From: Amanda Scholes on behalf of Planning.Responses
Sent: 30 June 2020 10:20
To: Planning Scanning
Subject: FW: FW: A/62/20/DOC - Pound Place, Roundstone Lane

I have the following comments regarding condition 3- surface water drainage:

TYPICAL SOAKAWAY DETAIL
"WAVIN AQUACELL"

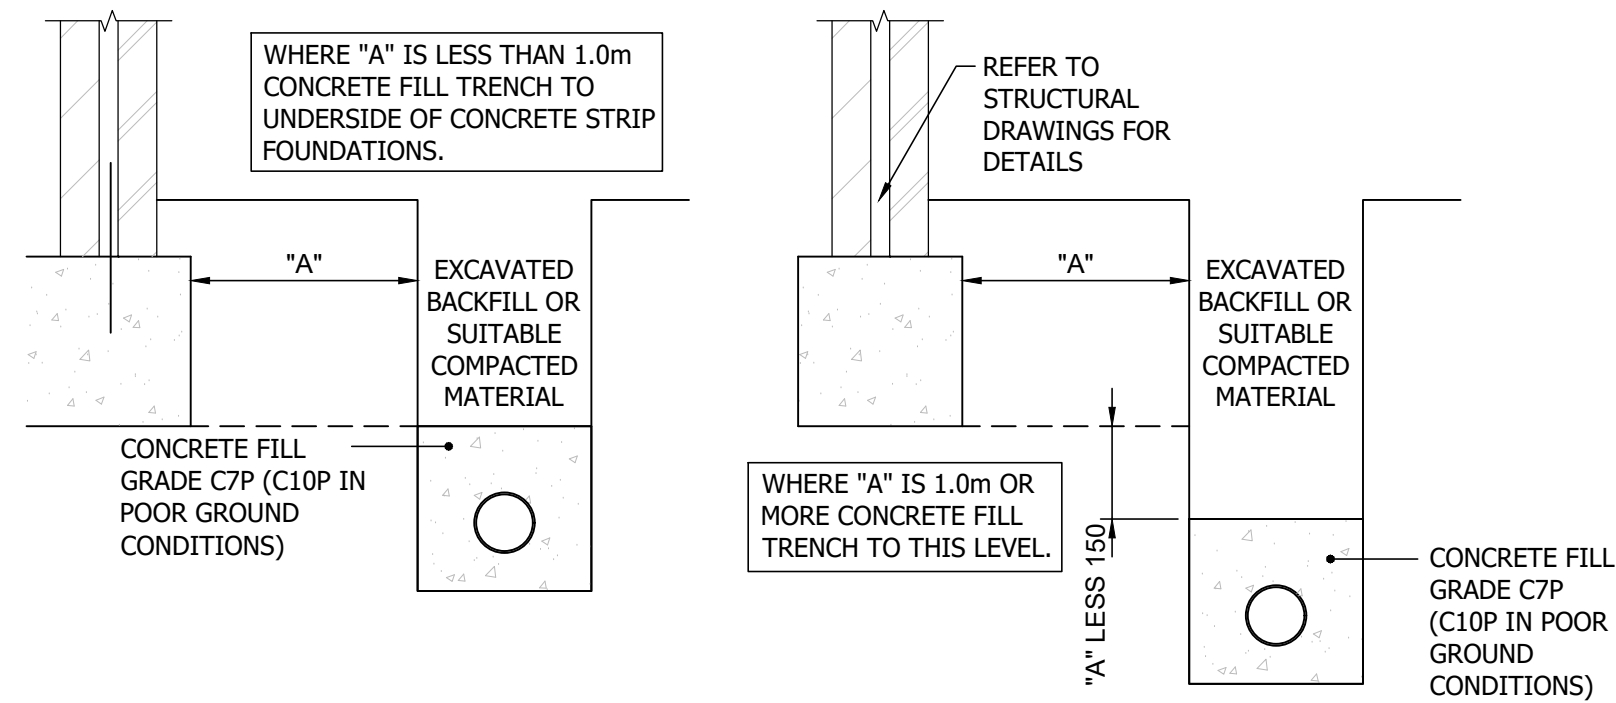
2. Please provide a revised catchment area plan.
3. Porosity of soakaways in calculations is set to 1, please correct to 0.95 as per standard for crates.

TYPICAL ROAD GULLY DETAIL

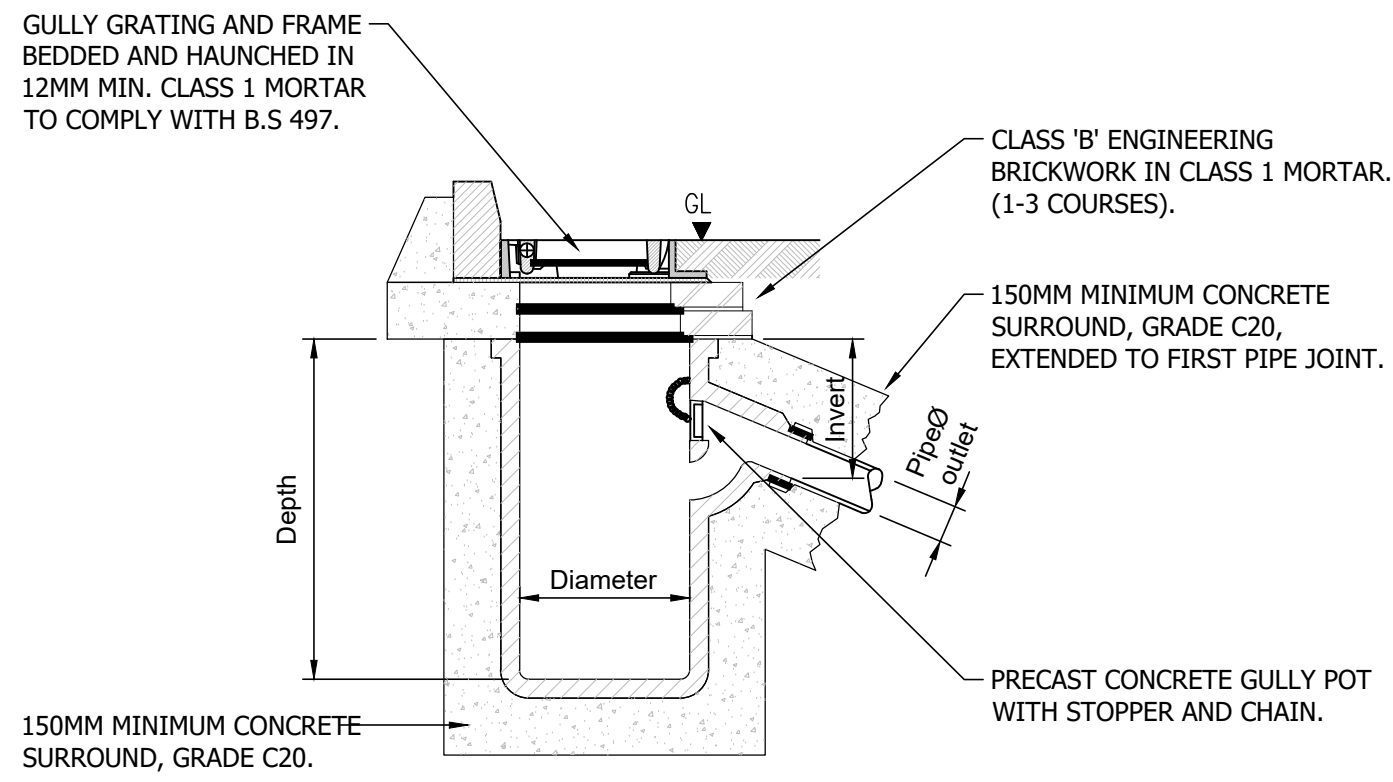
4. Please provide invert levels of diffuser blocks on plan. Please detail diameter of pipes connecting from these to network on plan.
5. Please detail cover level of gullies.
